24 August 2018

File No: SSD 6471
Our Ref: R/2014/13/C

**RE: ART GALLERY OF NSW EXPANSION PROJECT – SYDNEY MODERN –
SSD 6471 – RESPONSE TO SUBMISSIONS ADDENDUM REPORT**

DA_2000

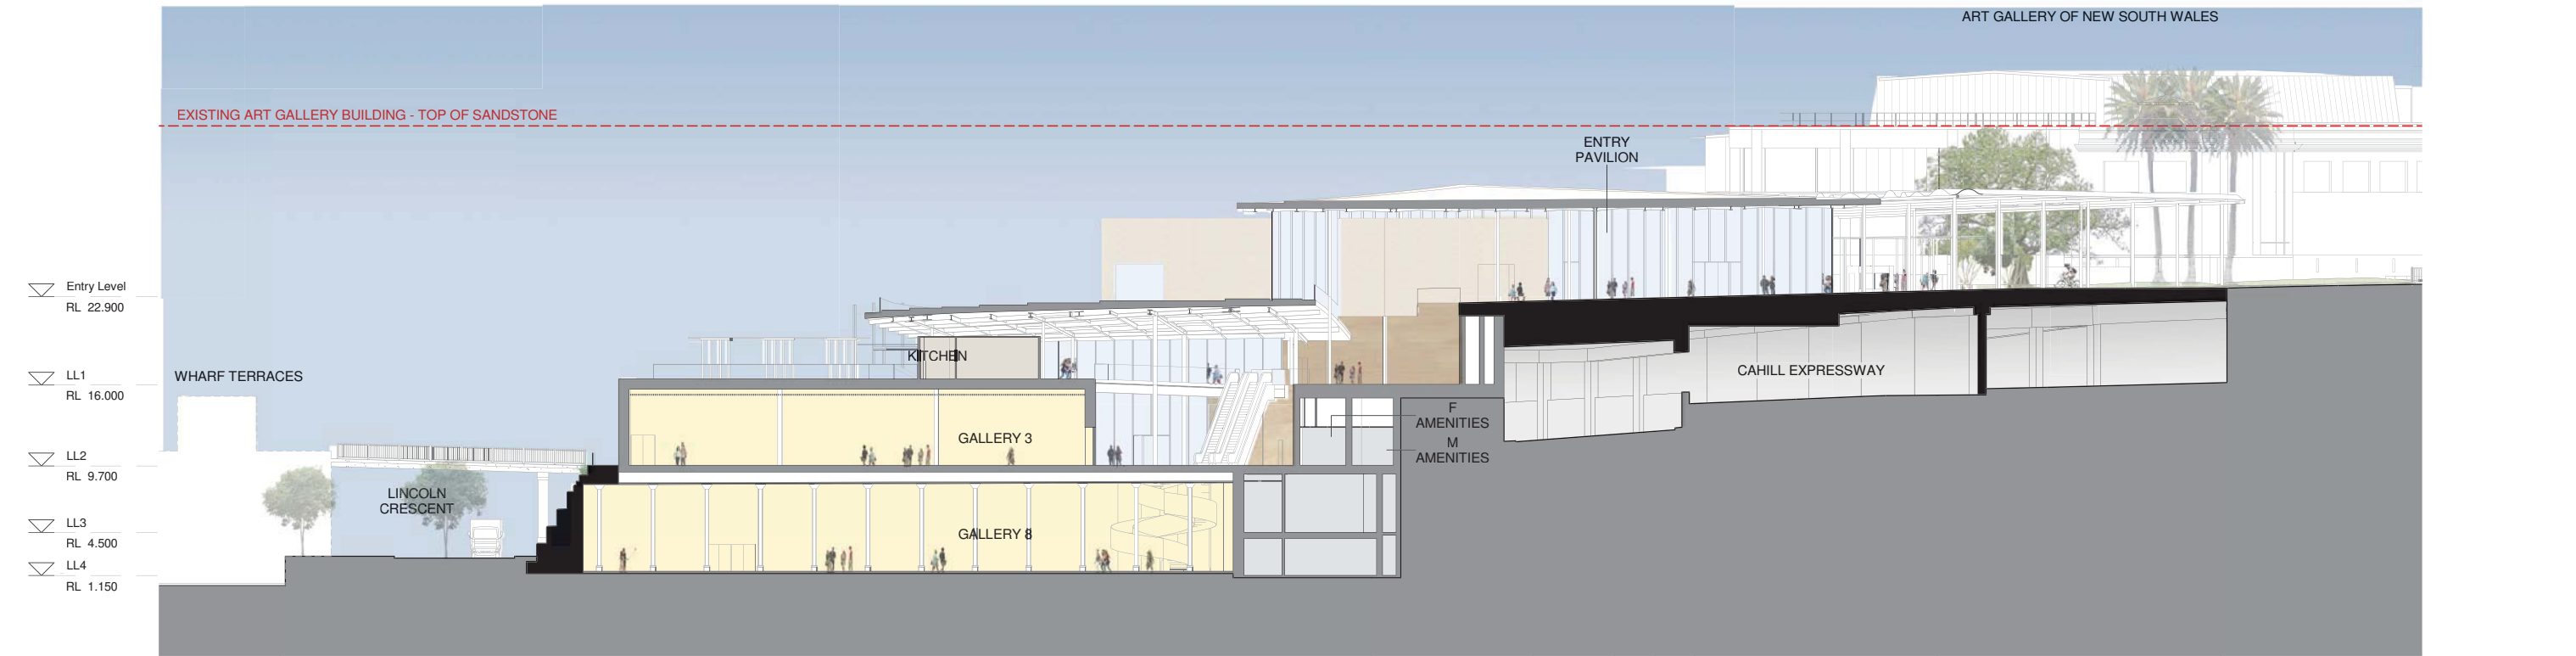
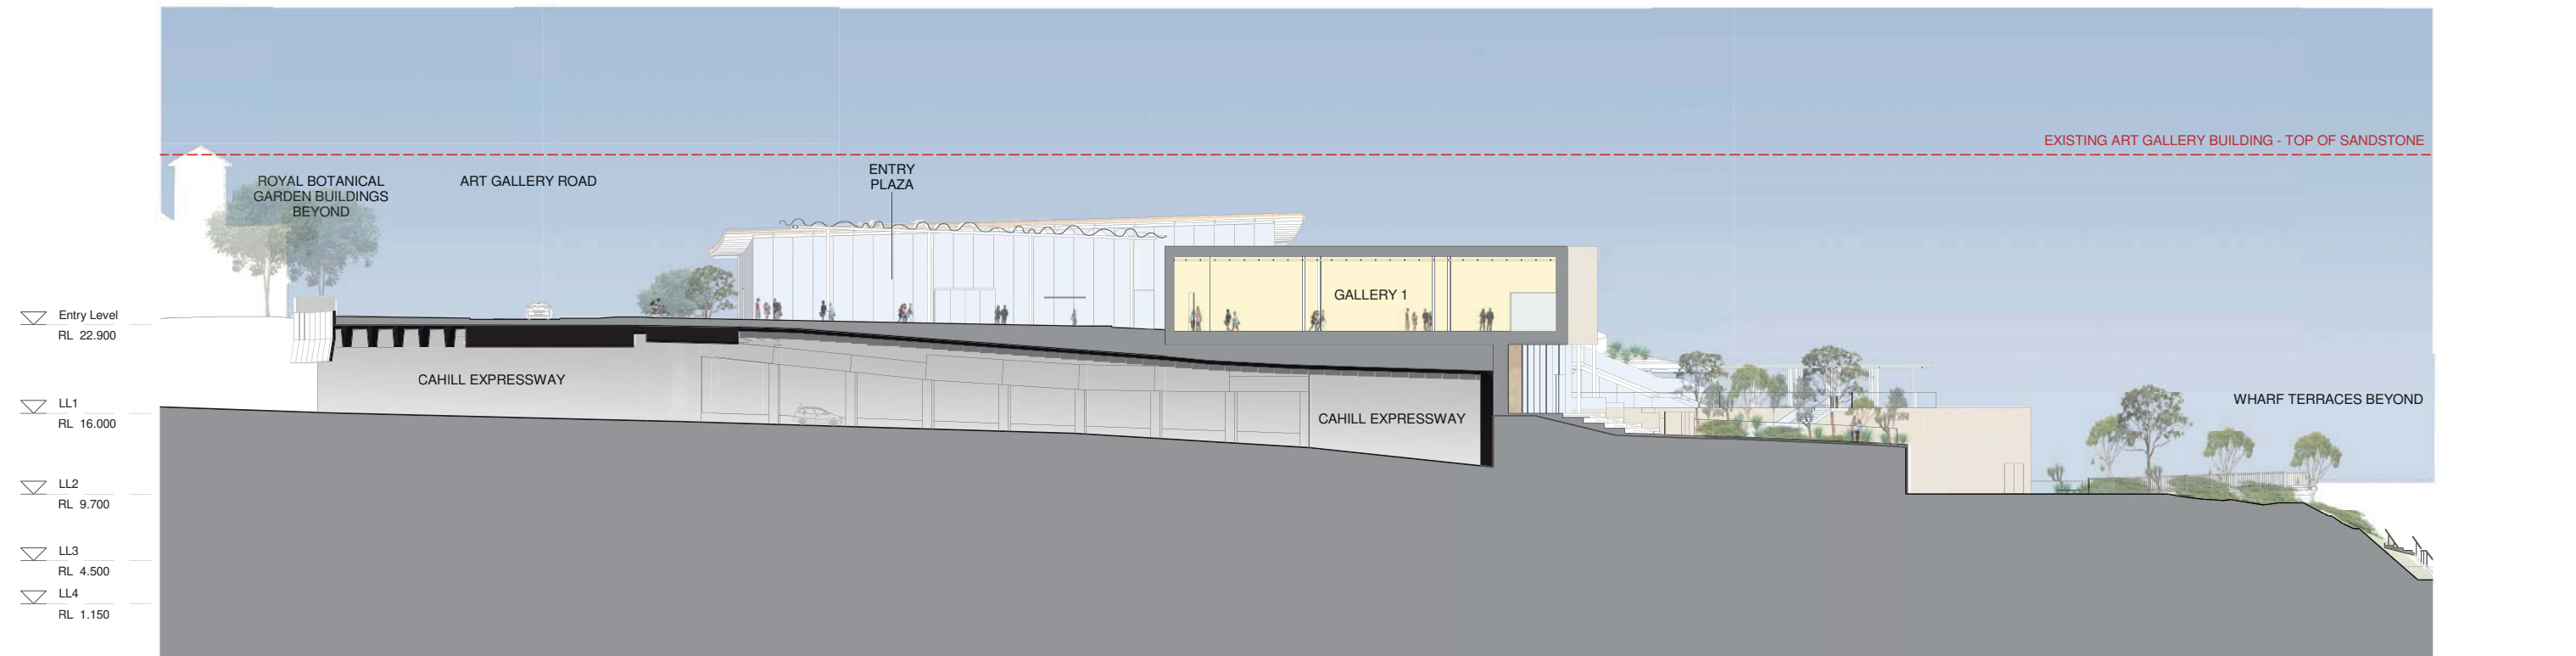
A stormwater plan detailing the proposed location of the basement areas accessible from the Art Gallery Road building entrances has not been provided. The requirement of the Flood Planning Level (FPL) is to be at a minimum of 0.3m above the gutter invert adjacent to the site is still applicable/recommended. However, where it deems not feasible to set the entrances threshold for the basement areas accessed from the Art Gallery Road to be at 0.3m above the gutter invert adjacent to the site, consideration can be given to the FPL to be considered to be at a minimum of 200mm above the gutter invert adjacent to the site Subject to further assessment satisfactory addressing the following issues:

drawing no.	Revision																																		
DA_1003	L

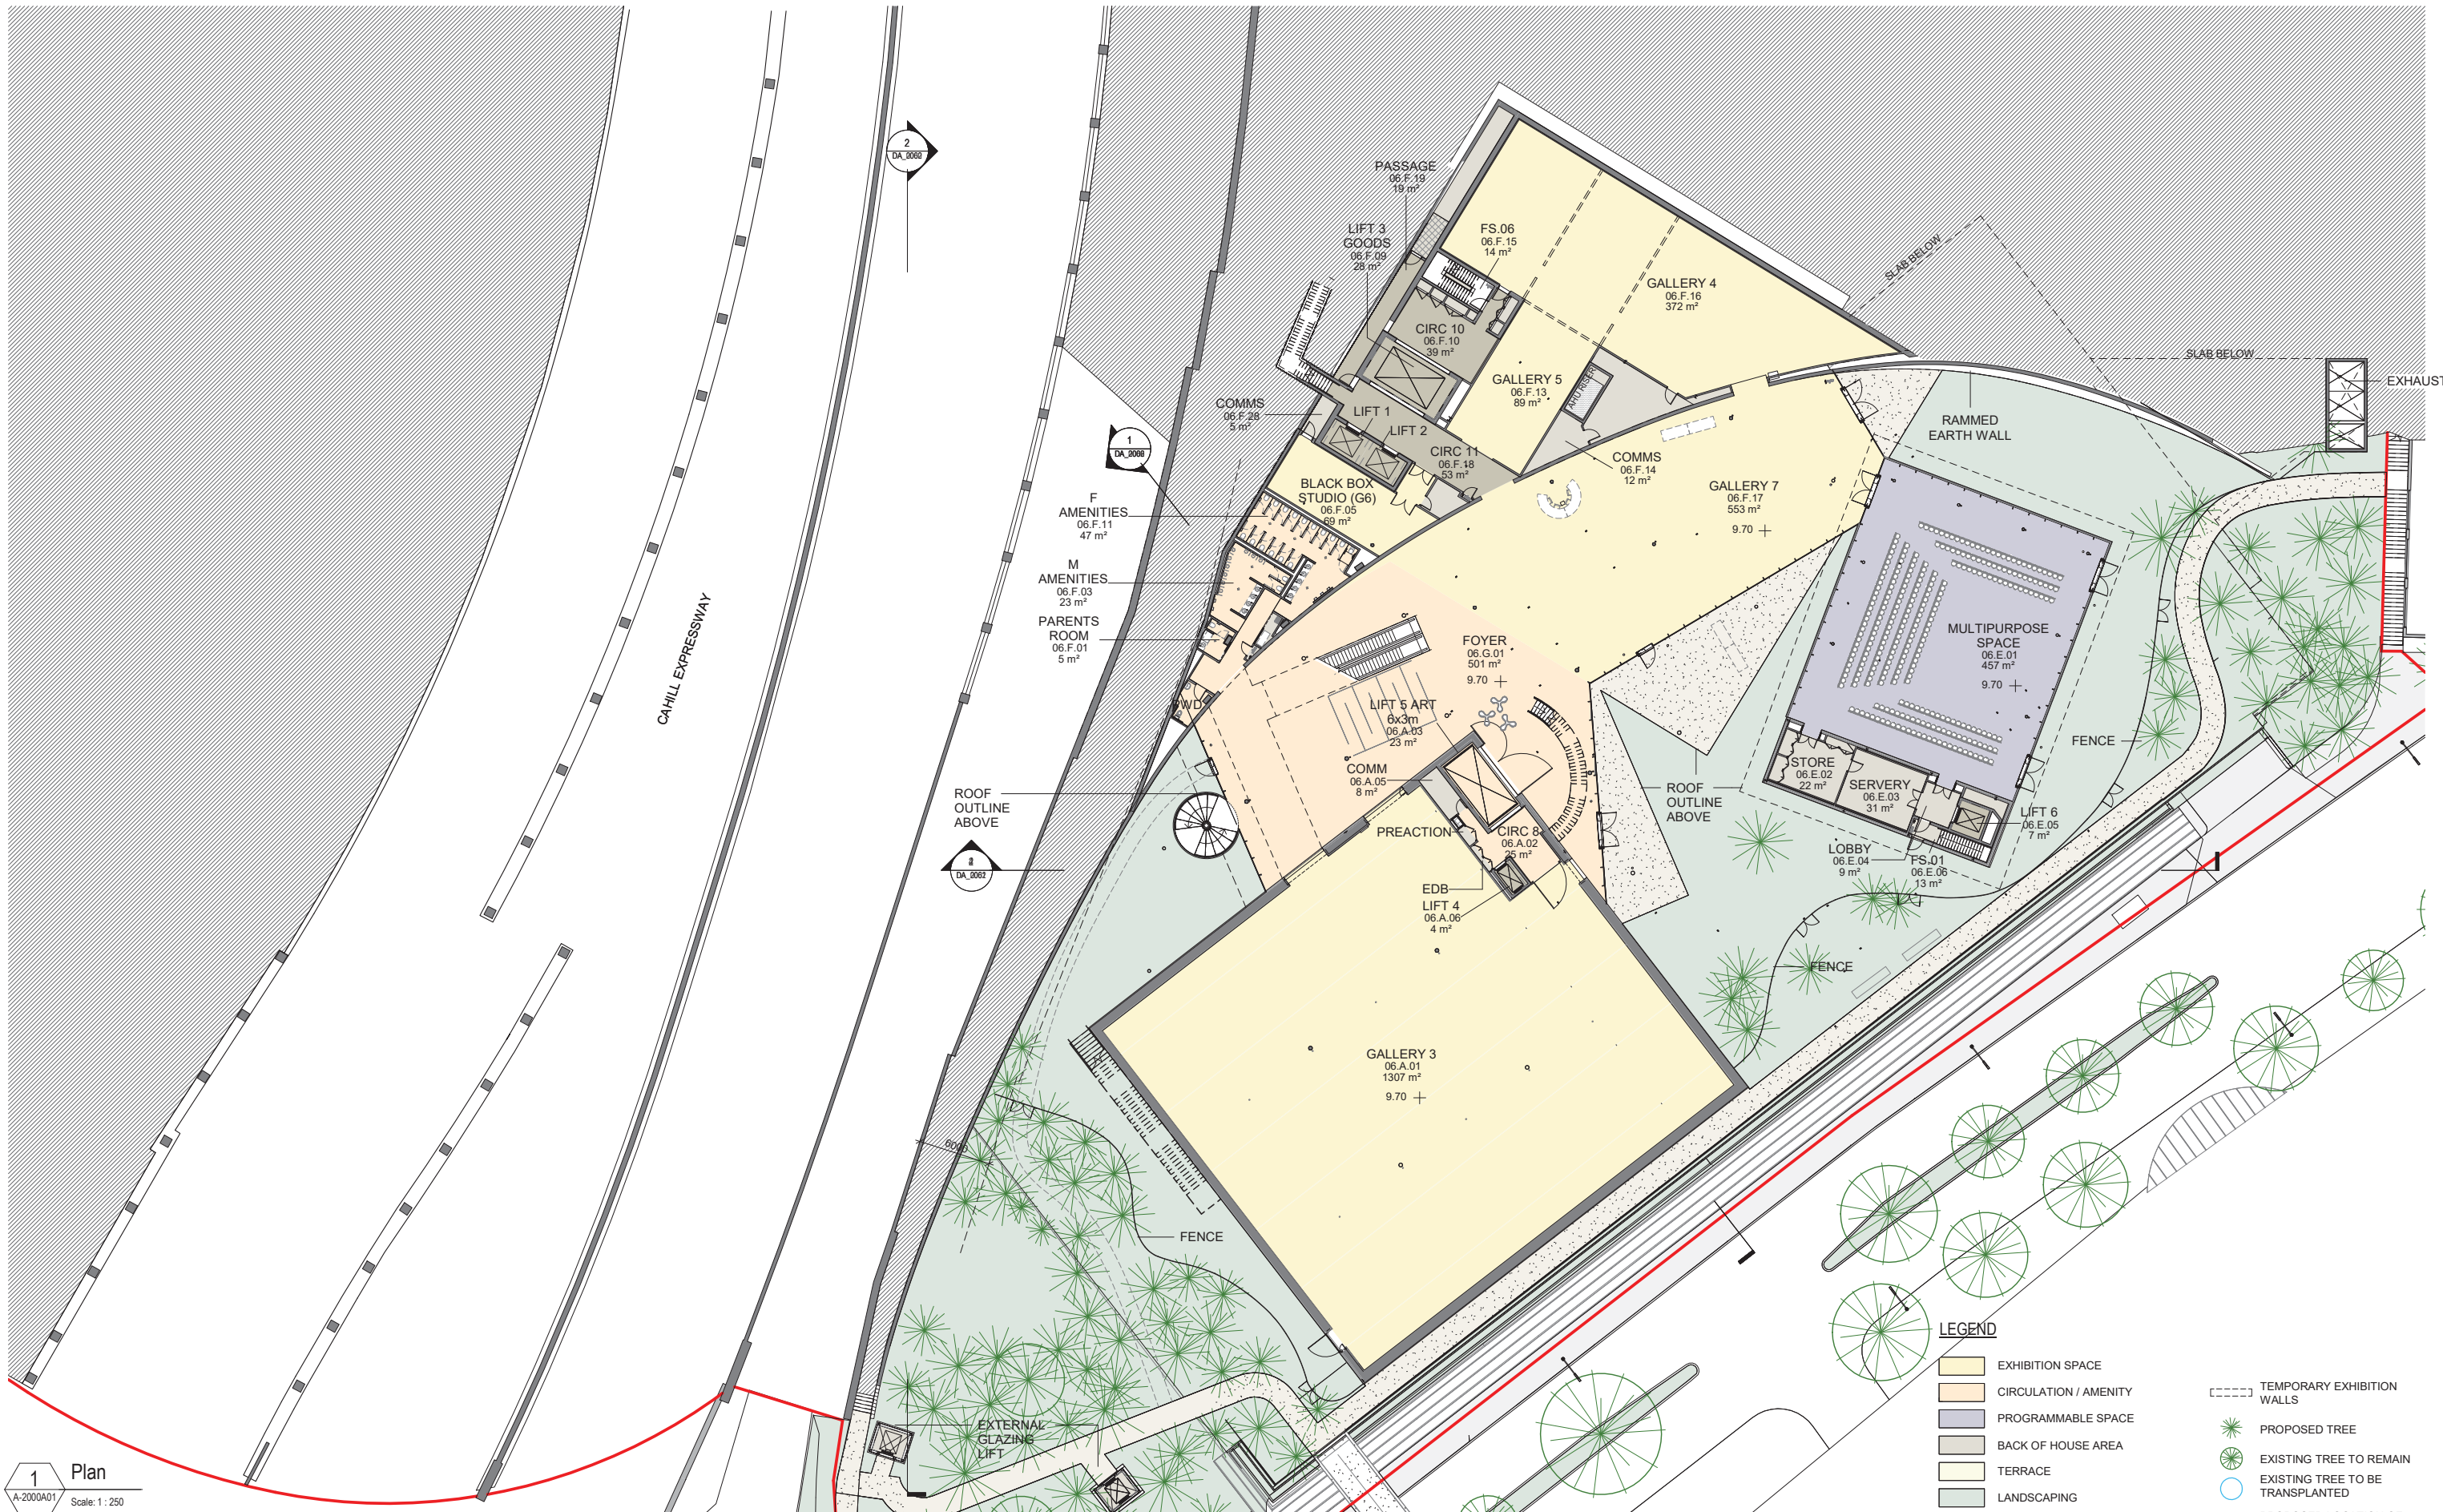
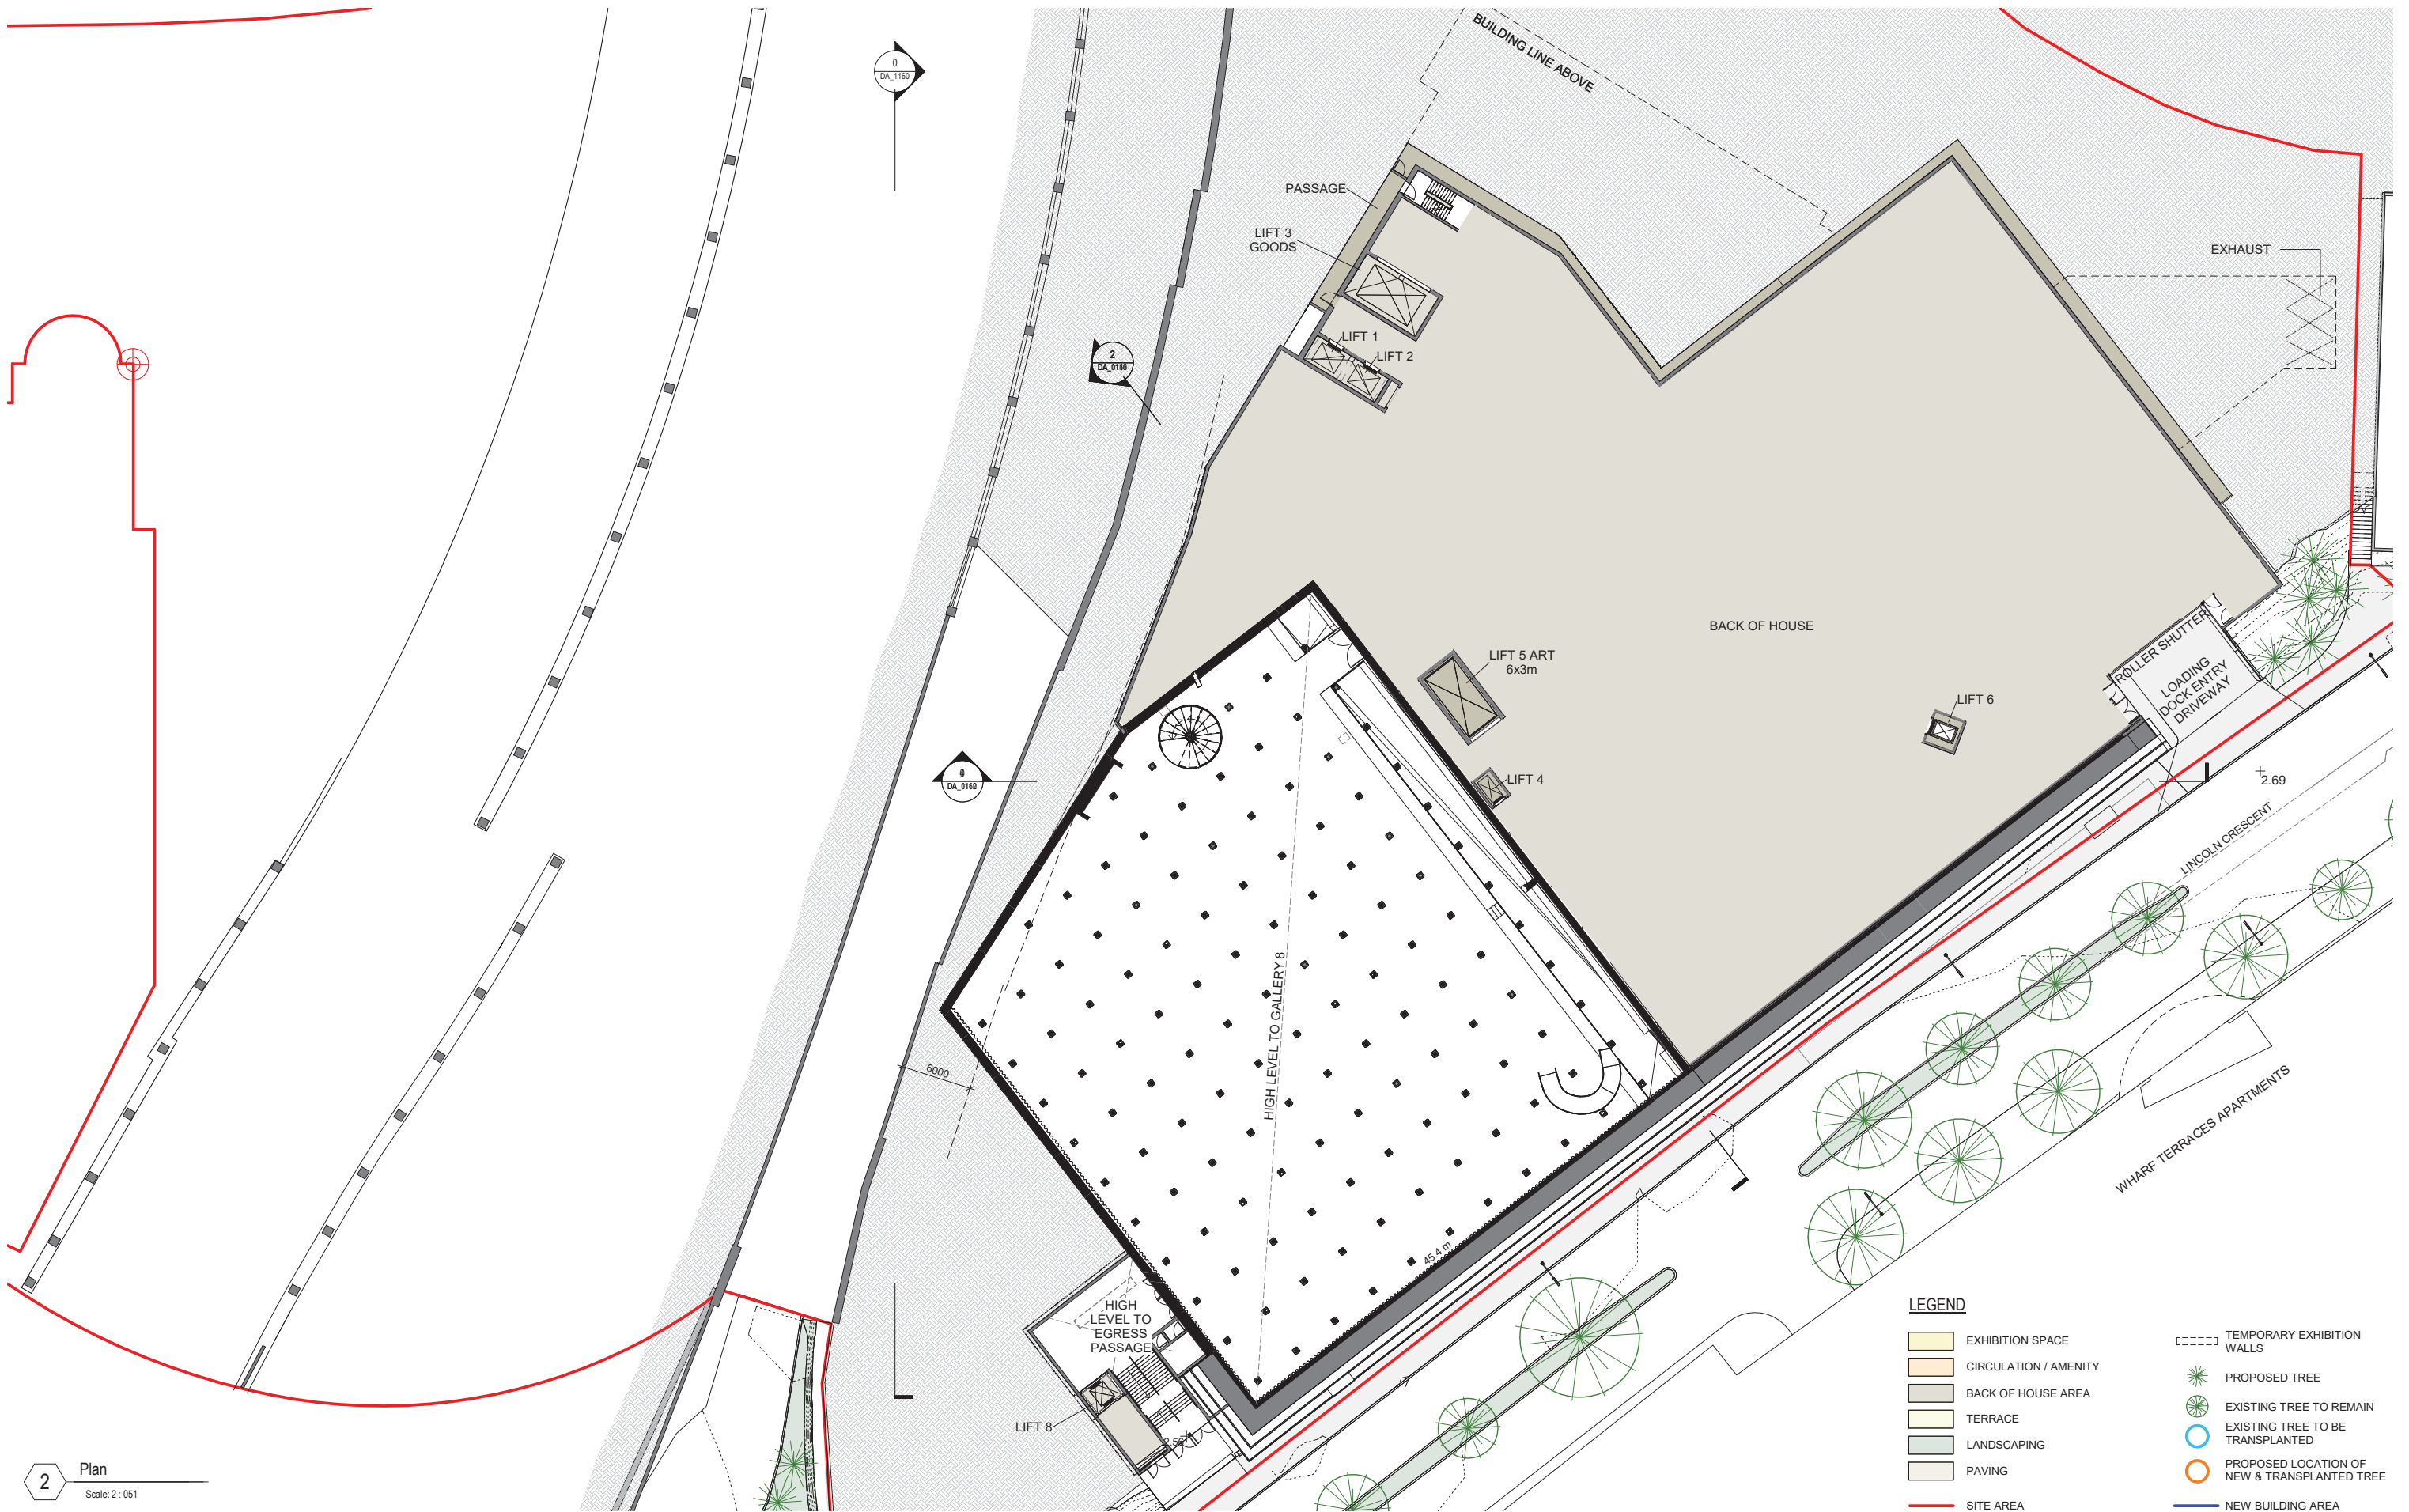
Several aspects of the described changes are unclear in terms of what is being proposed or amended as part of this addendum. It is not clear what changes are being made to the layout and configuration of the accessible parking, taxi zone and coach parking on the eastern side of Art Gallery Road on the architectural plans. It should be clarified whether the existing pedestrian crossing on Art Gallery Road is being removed as it is not shown on plans but not described as being removed. As noted previously, the removal of this crossing point is not supported. It is not clear how the new access lift from Lincoln Crescent would be accessed from Lincoln Crescent.

Previous comments regarding the footpaths along the western side of Art Gallery Road remain applicable. Where the existing stairs towards the Domain are to be removed, ease of movement in a north – south direction along Art Gallery Road should be maintained in terms of levels and widths of the footpath.

The pedestrian links between lifts from Lincoln Avenue to the art garden will require a strong wayfinding strategy to be a legible accessible route.
